Application no: H16/0797/00

Applicant: Cley Developments Ltd.
Willow Lodge
Horseshoe Road
Spalding
Lincs. PE11 3JA
Description: Proposed dwelling and garage

Location: Plot 1, Westbourne Gardens
Spalding

Amendment: Dwelling repositioned - brought forward on plot, garage
reduced in length, en-suite rooflight sited on n. elevation

Drawing Title
Ground - First Floor Plans

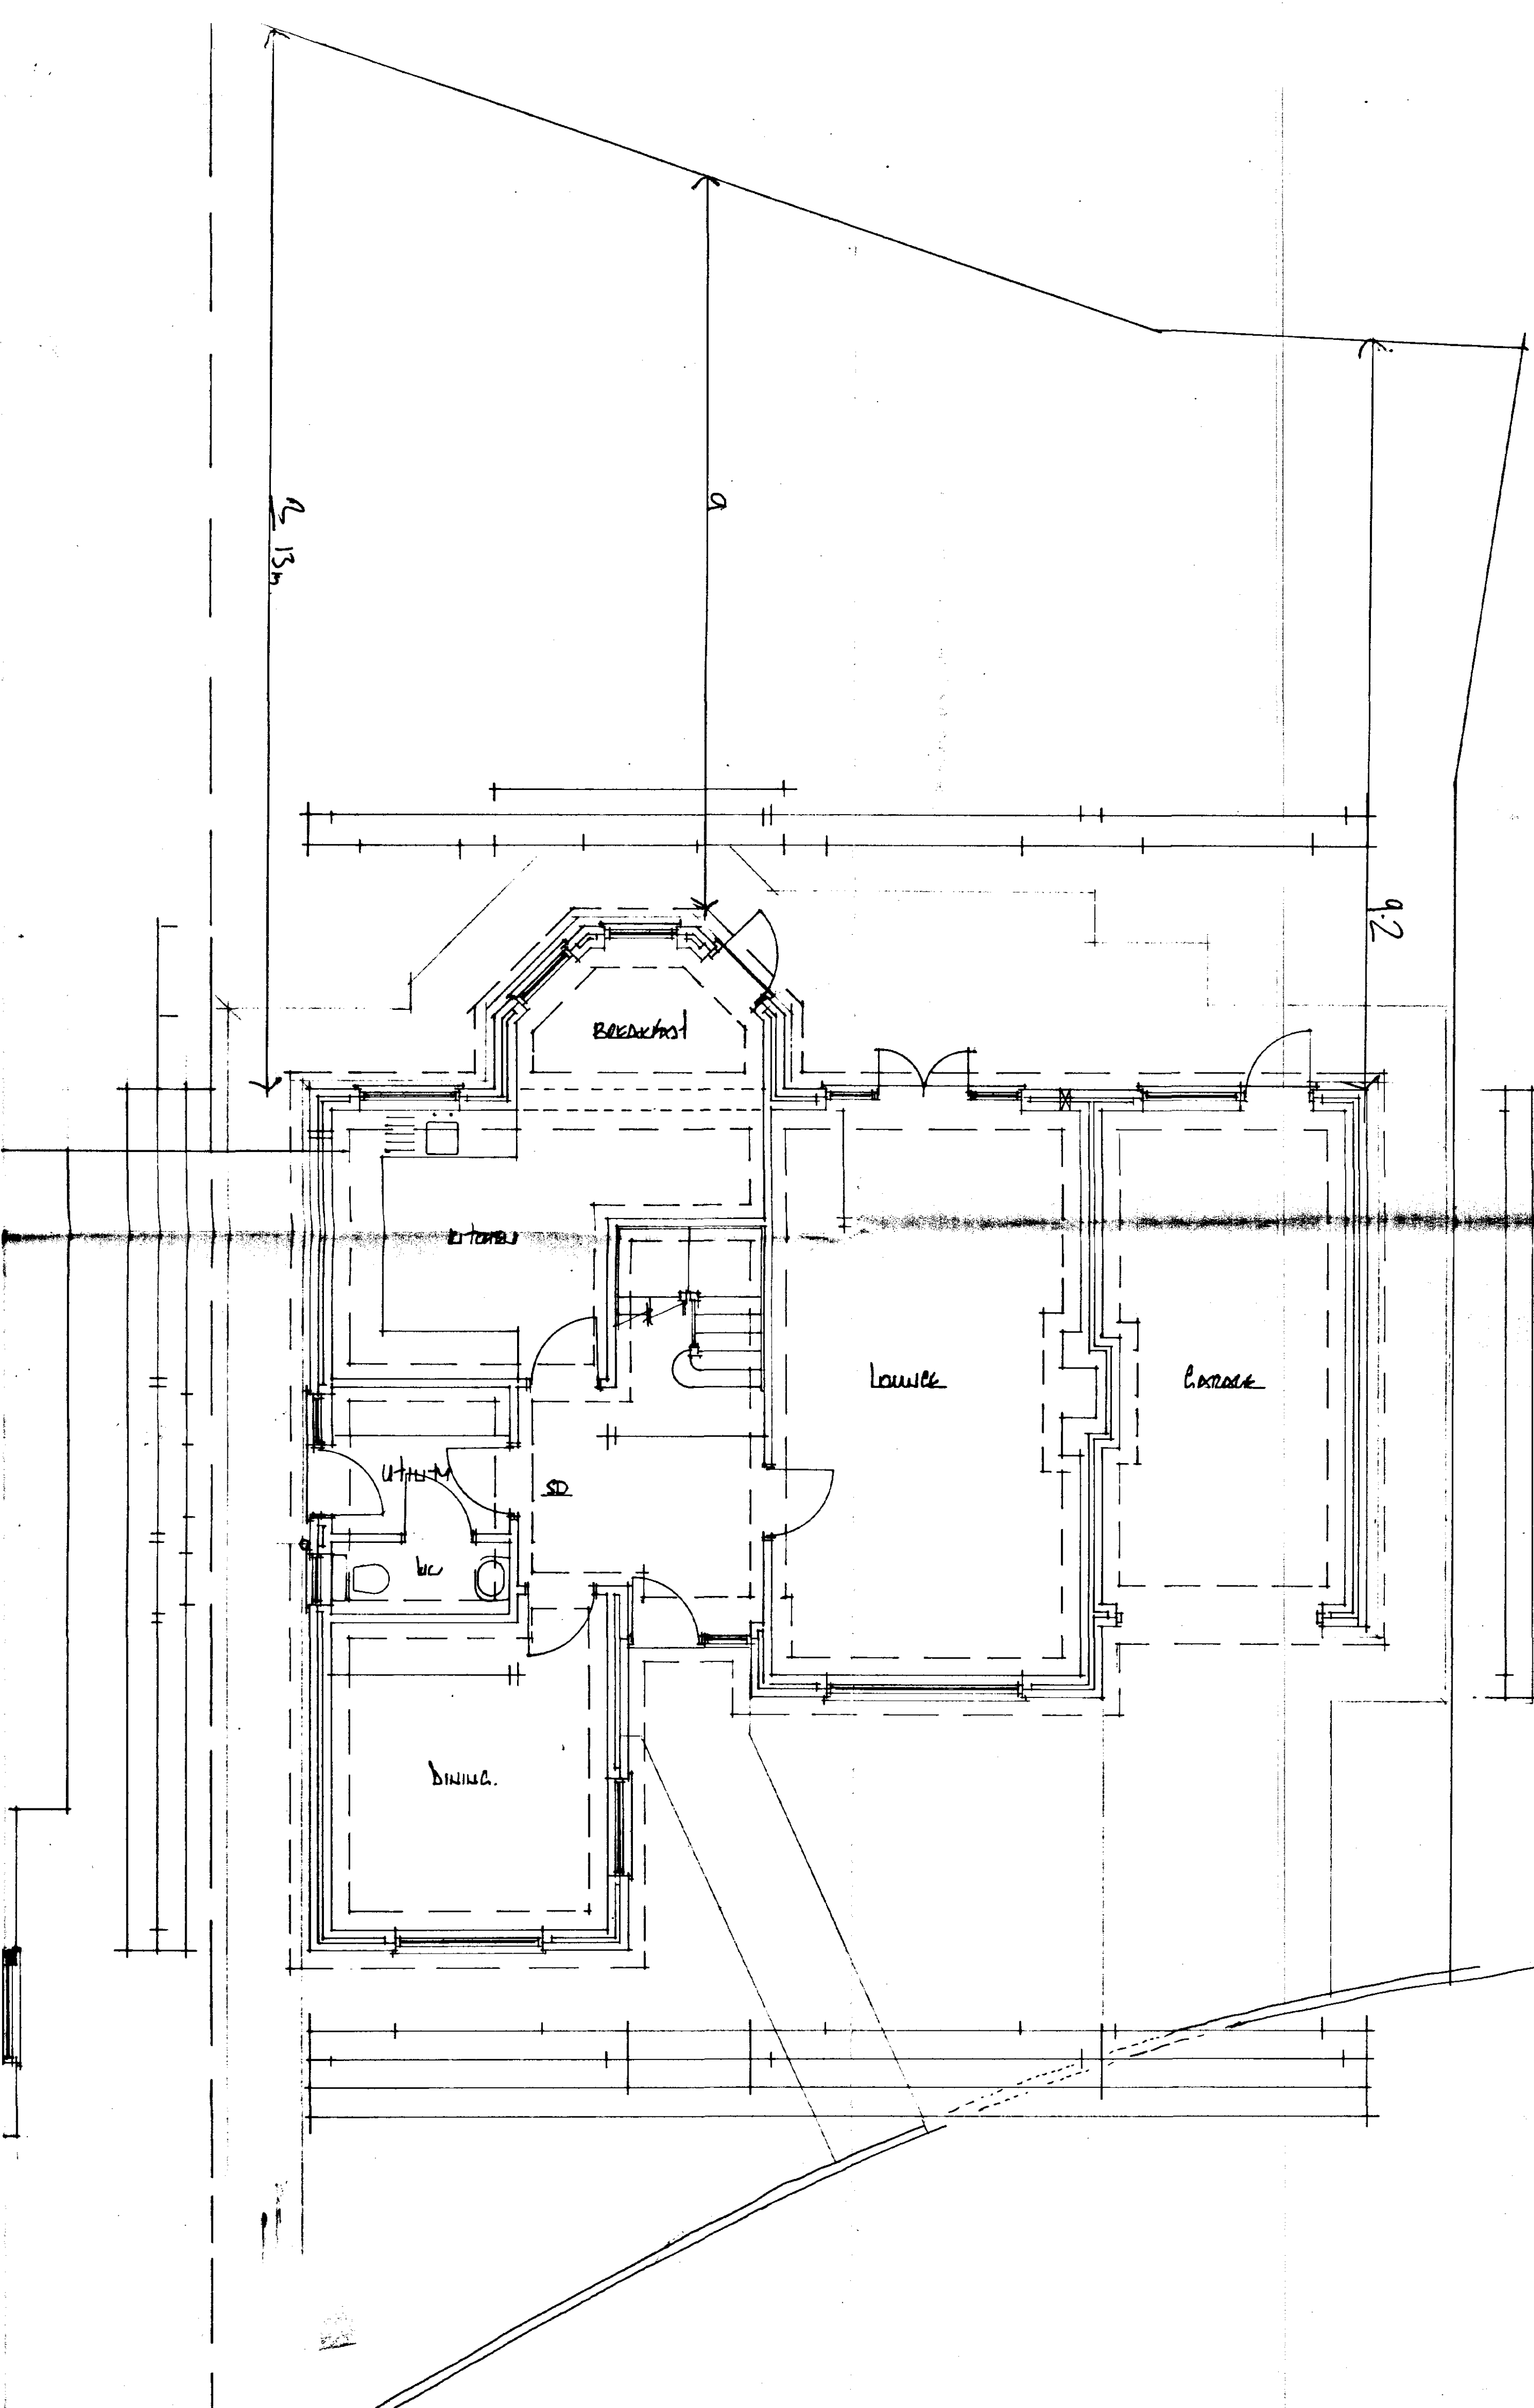
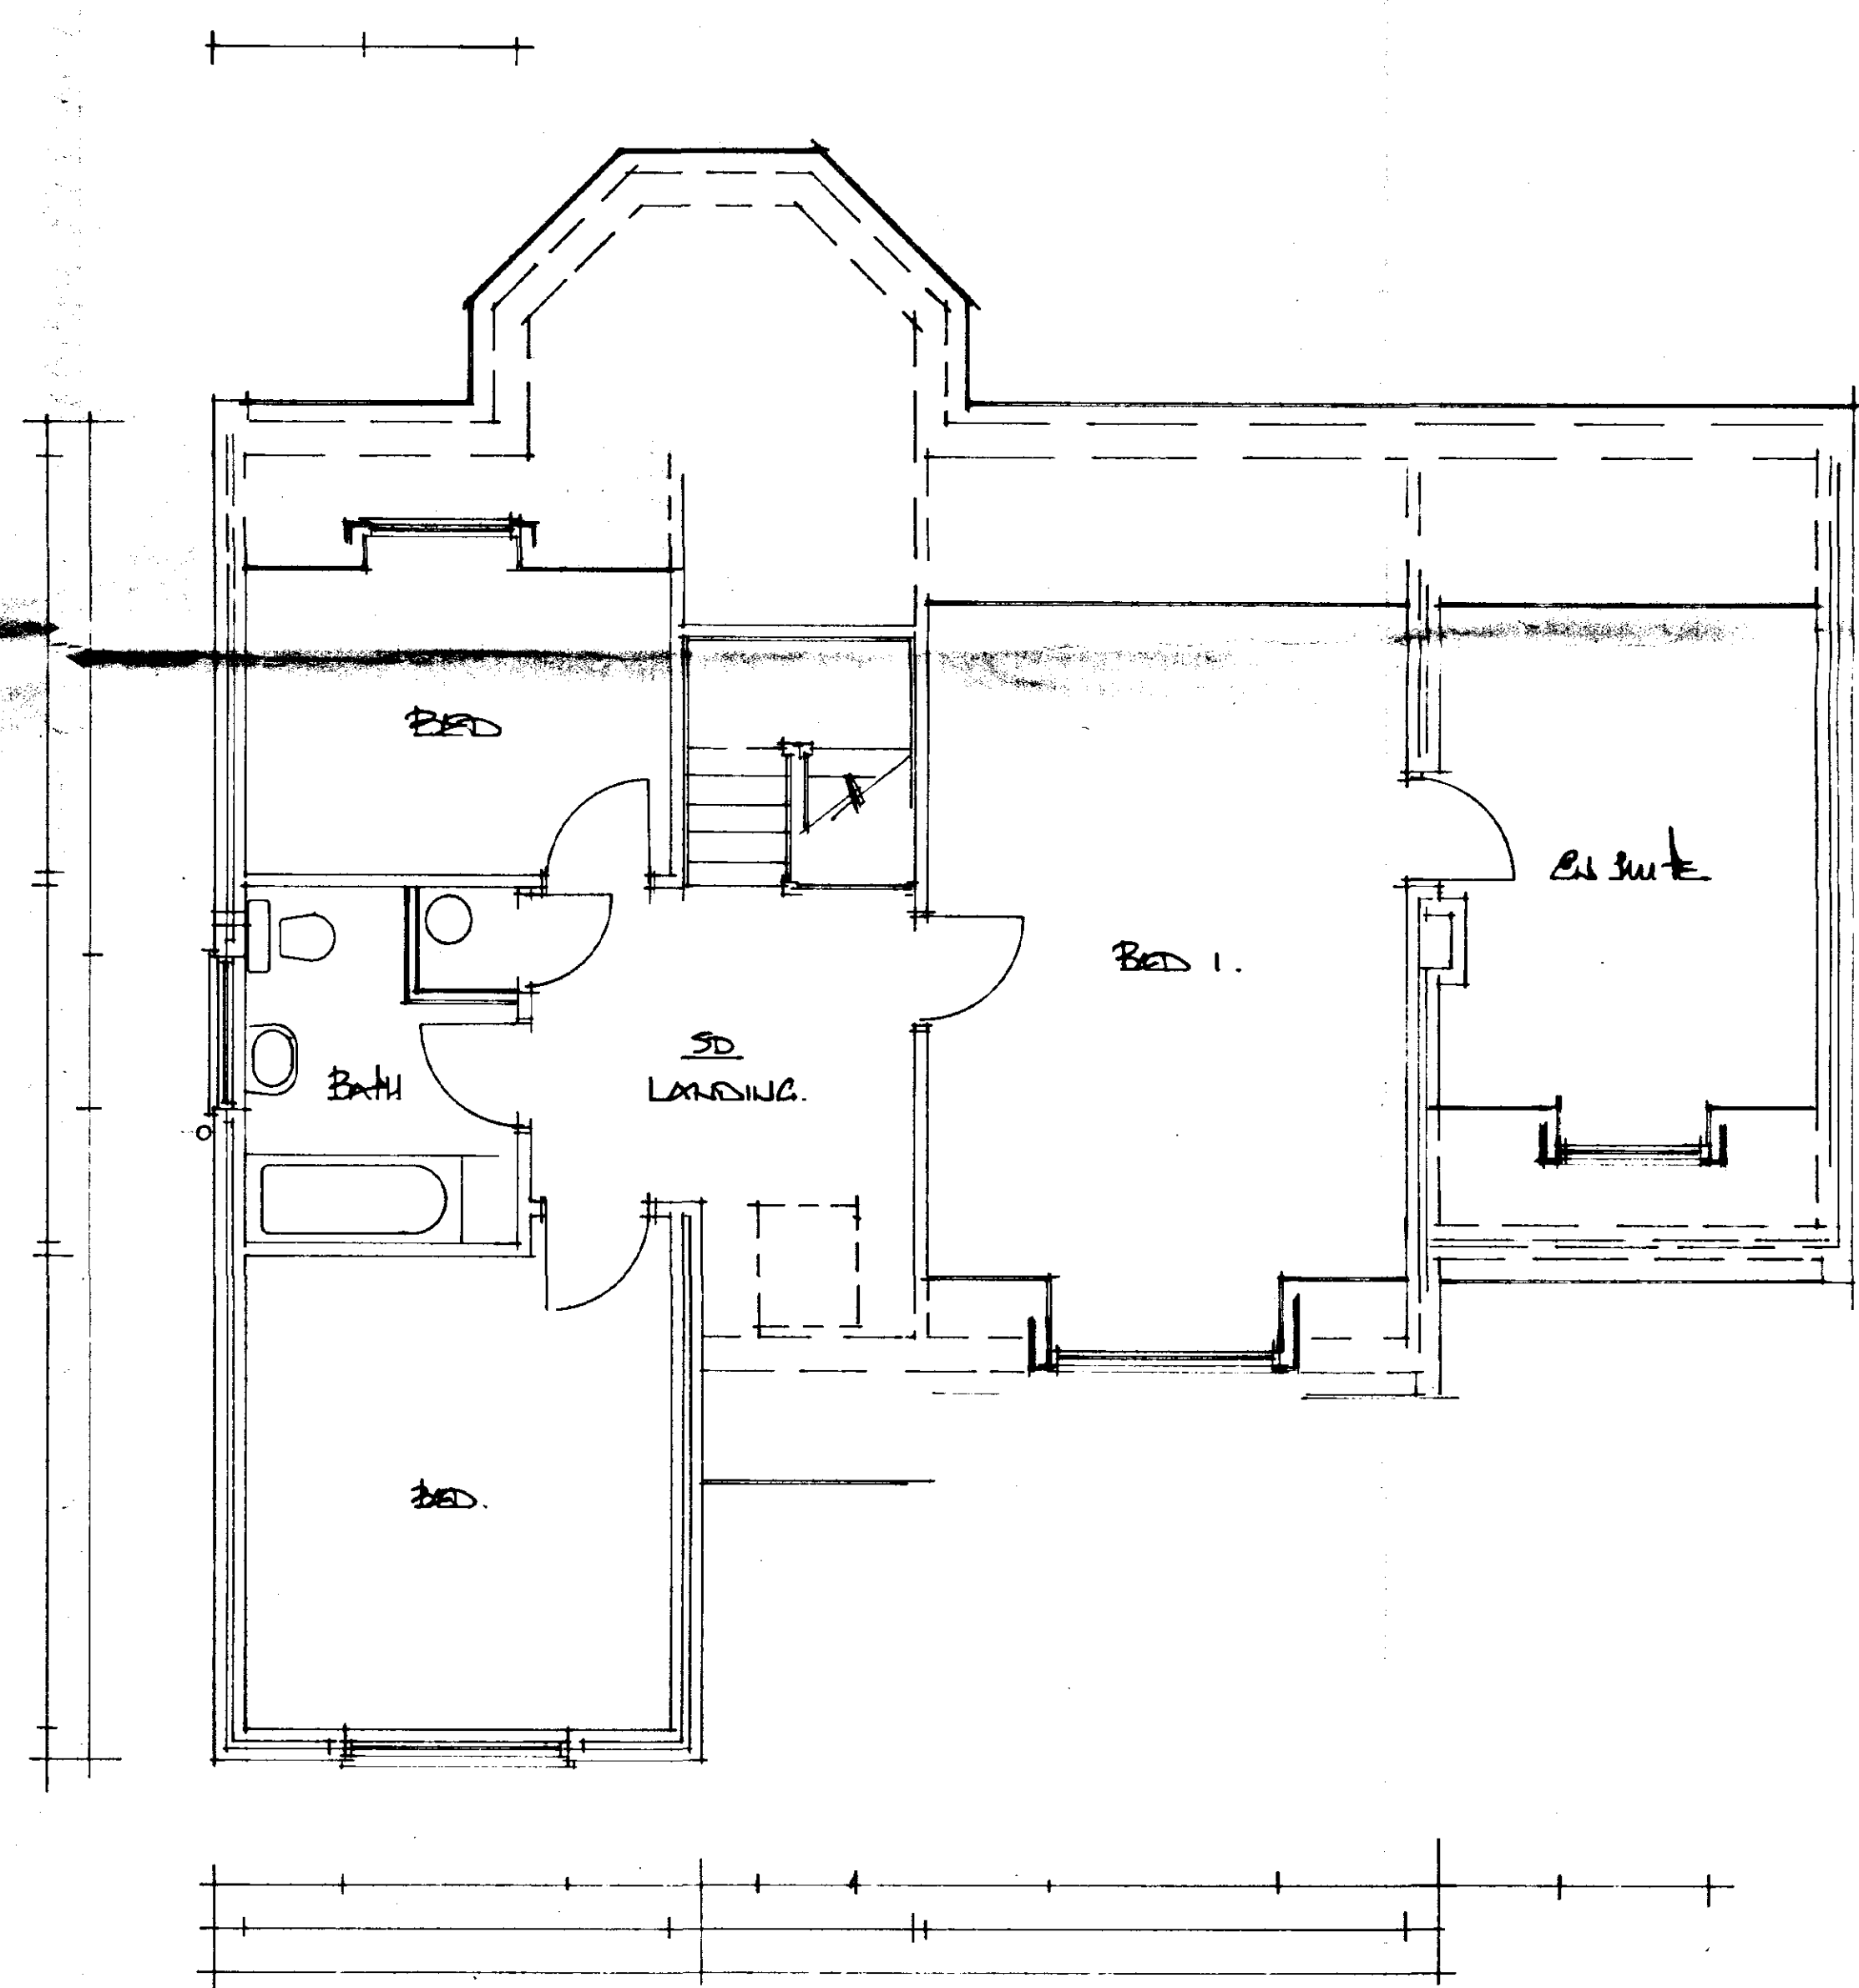
SKEDLINE REPOSITIONED - BROUGHT FORWARD ON PLOT.
GARAGE REDUCED IN LENGTH ON SUITE ROOFLIGHT SITED ON NORTH ELEVATION.
